RE: **Durango Subdivision, Units 3- 5**
Erosion and Sediment Control Plan
Engineer's Stamp Date 03-19-19 (C09E012A)

ESC-1

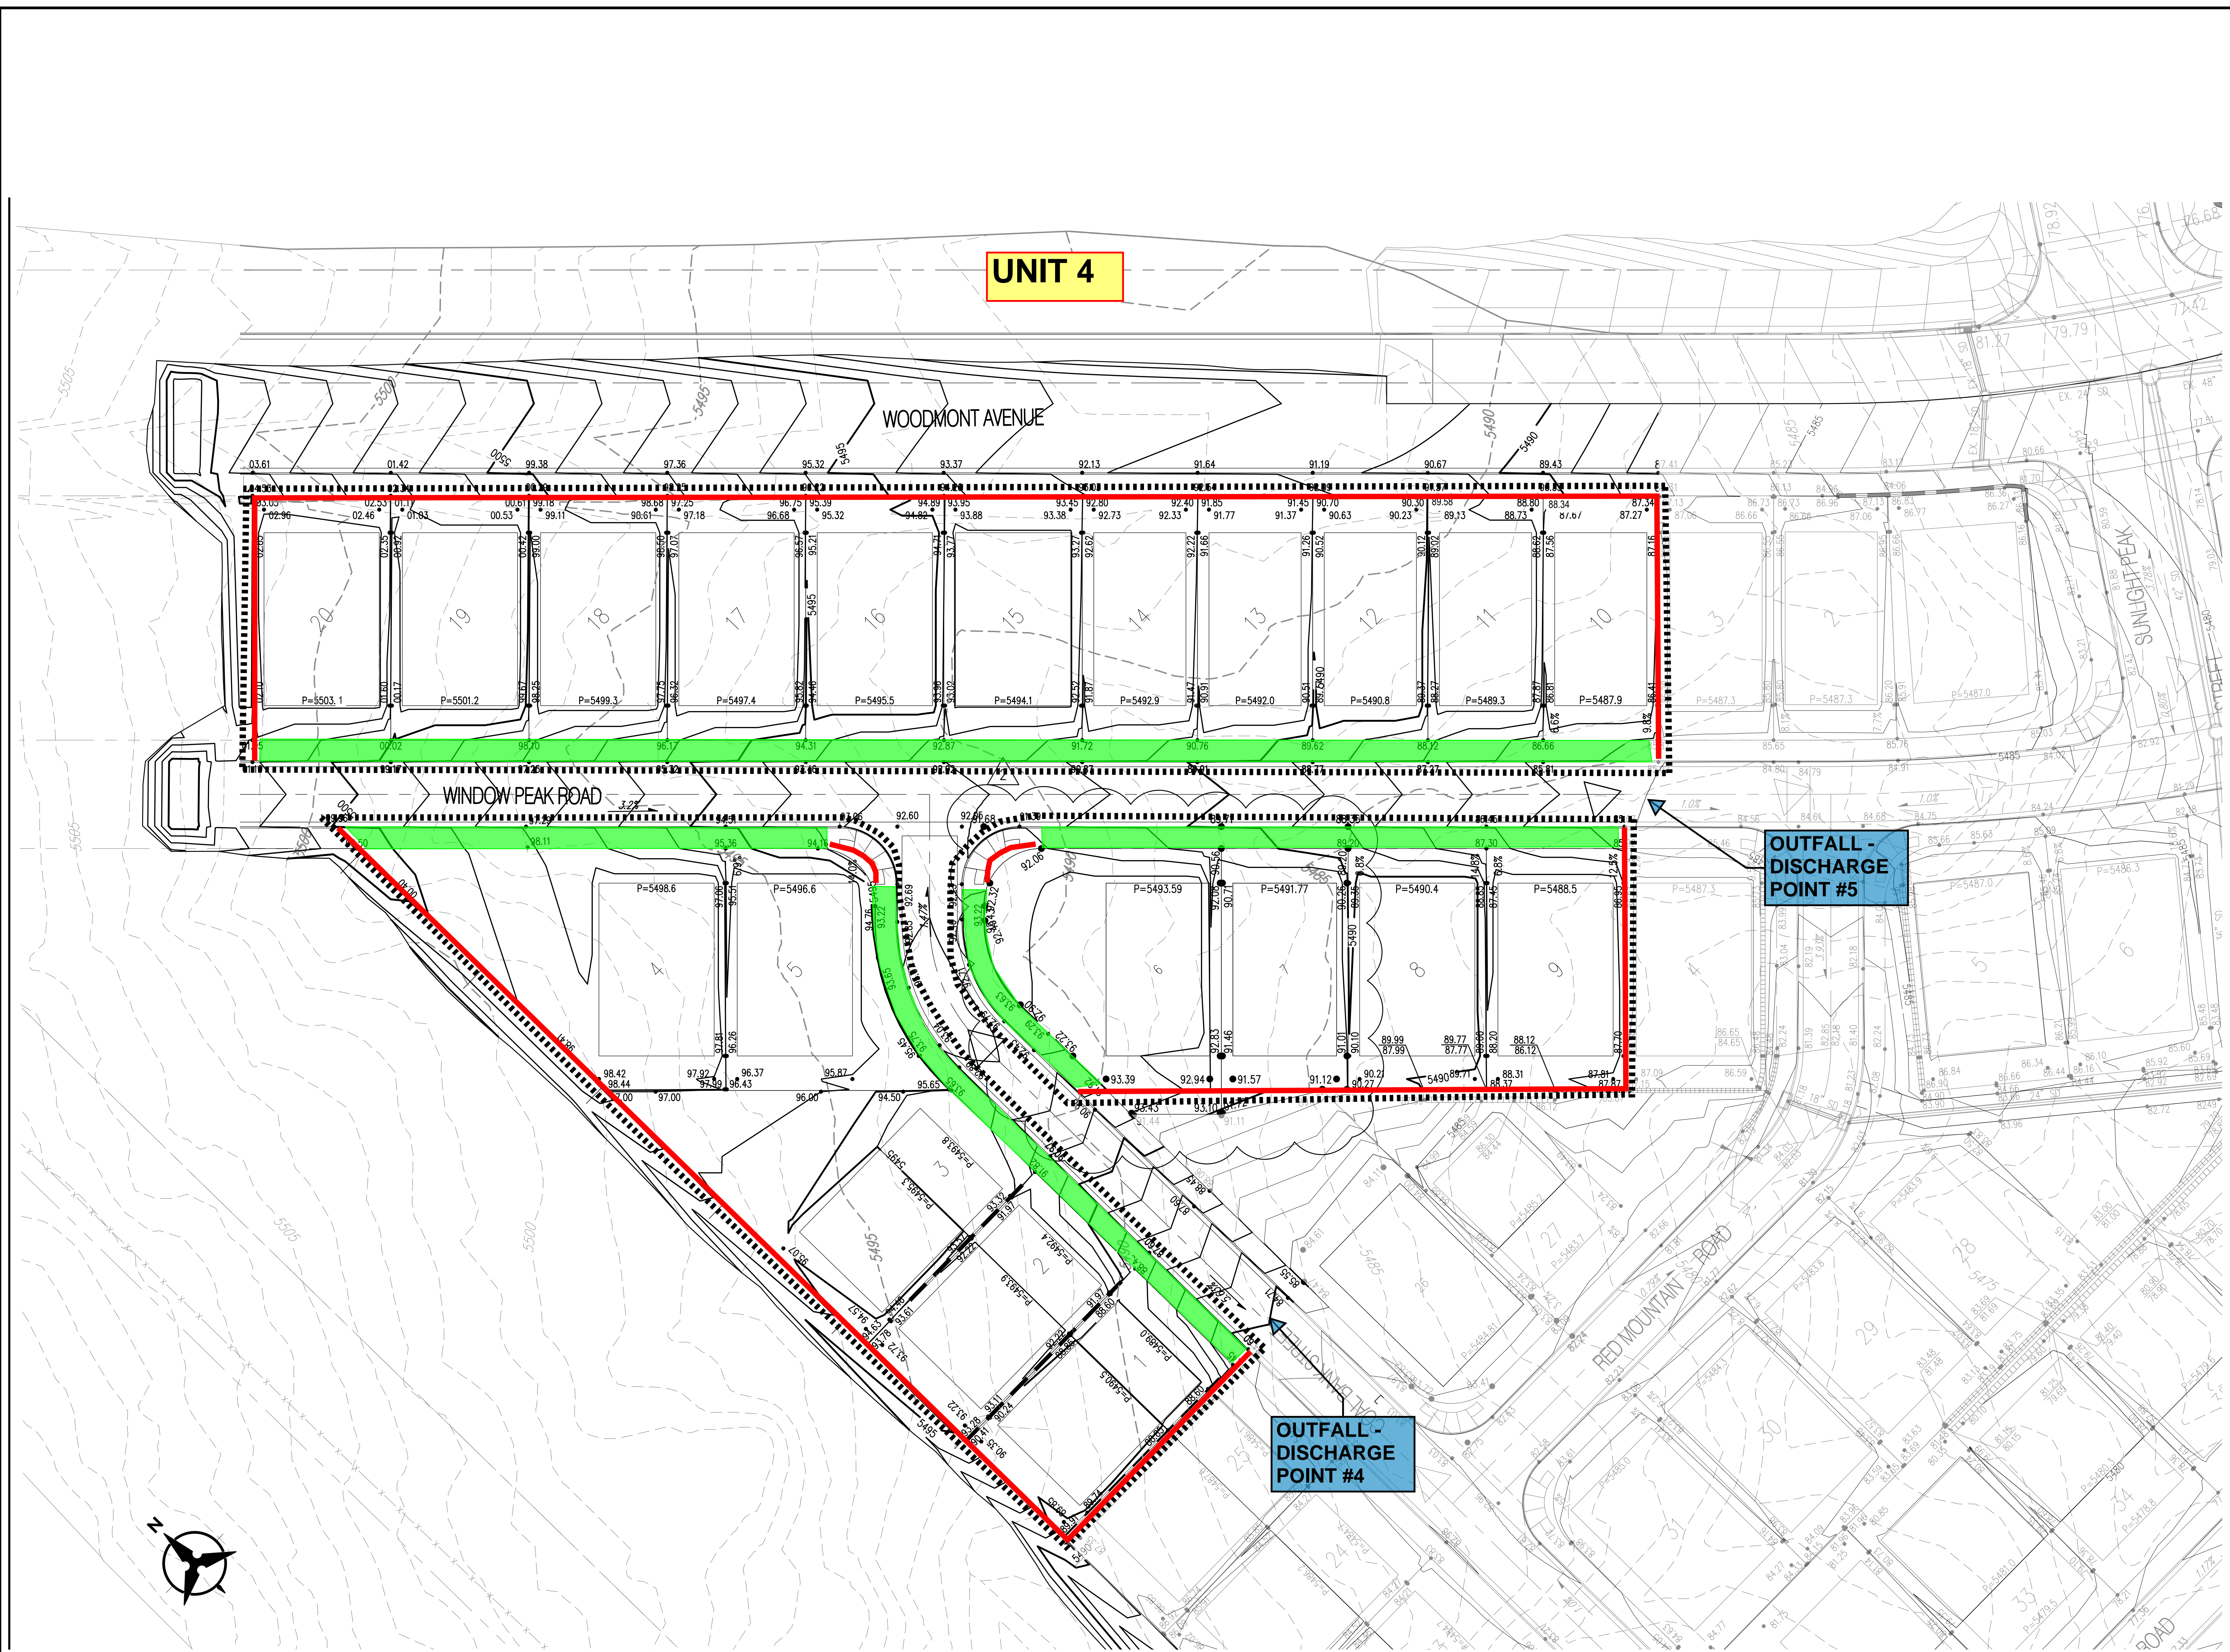
1. This site is approximately 18 acres. Temporary sediment pond(s) are required. It appears the best location(s) for the ponds may be: downhill end of Window Peak Rd, downhill end of Weminuche Rd and either the downstream end of Molas Rd or Red Mountain Rd and the downstream end of Woodmont Blvd off to the side of the stabilized construction entrance. **Sediment control ponds have been placed on the erosion and sediment control plan.**

Cut-Back Curb Detail

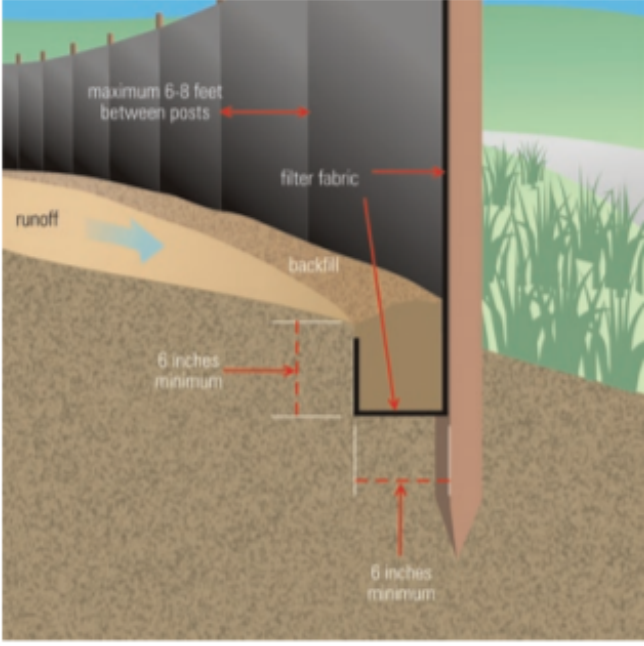
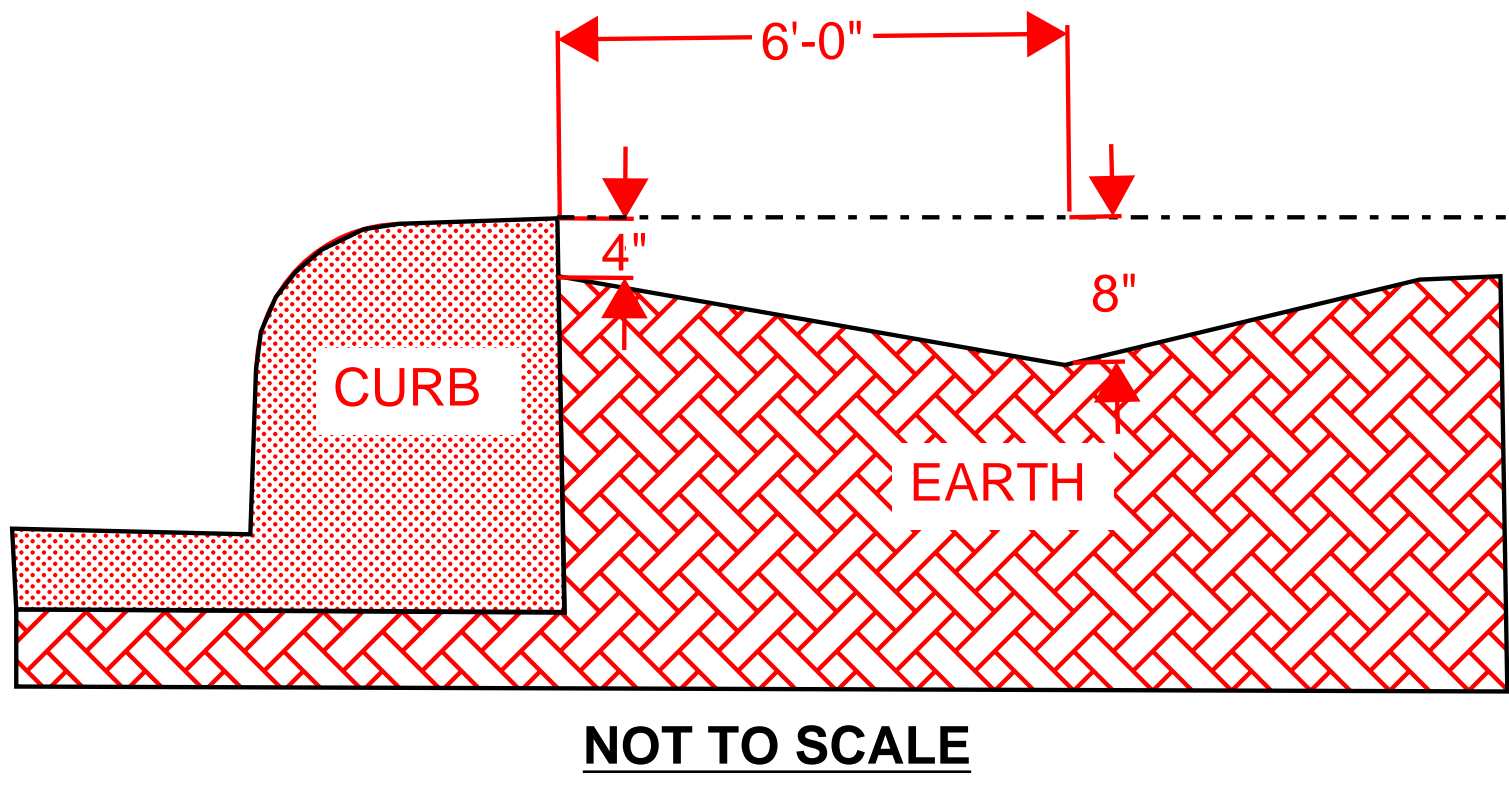
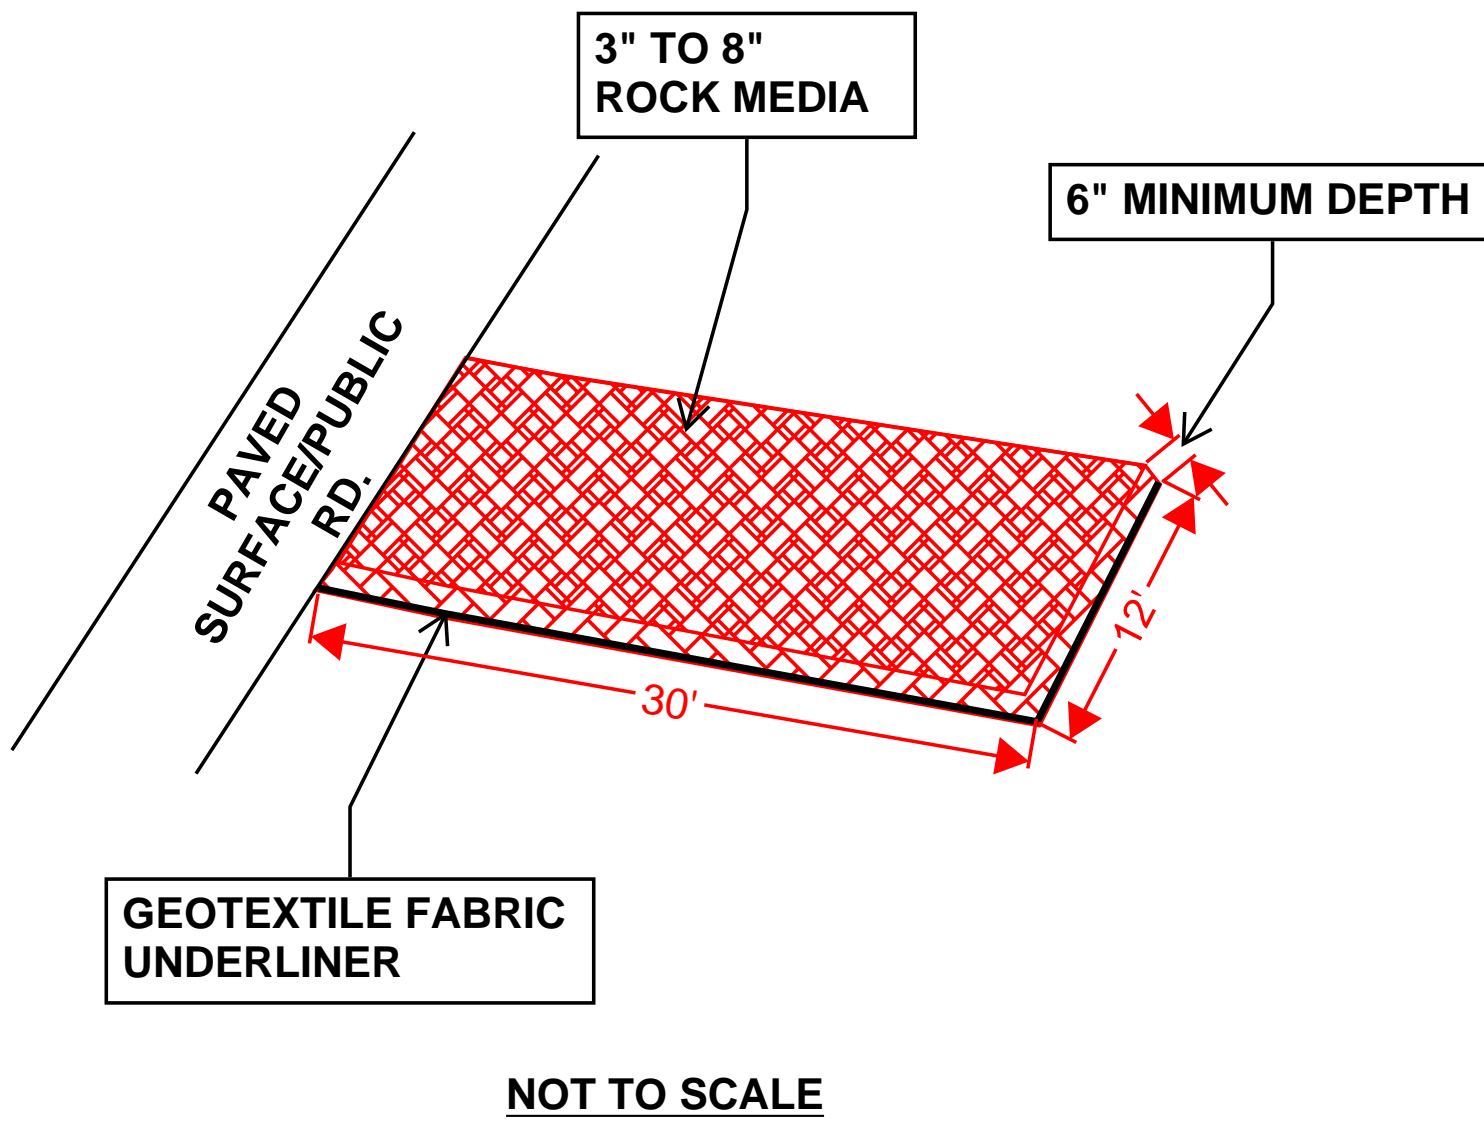
2. Once streets are constructed and pads are graded, a sediment BMP is required on every lot. Most developers are using a cutback-behind-the curb, but silt fence or mulch sock is acceptable. A detail of the cutback will accompany this letter. **This detail was provided on the second sheet of the erosion and sediment control plan.**
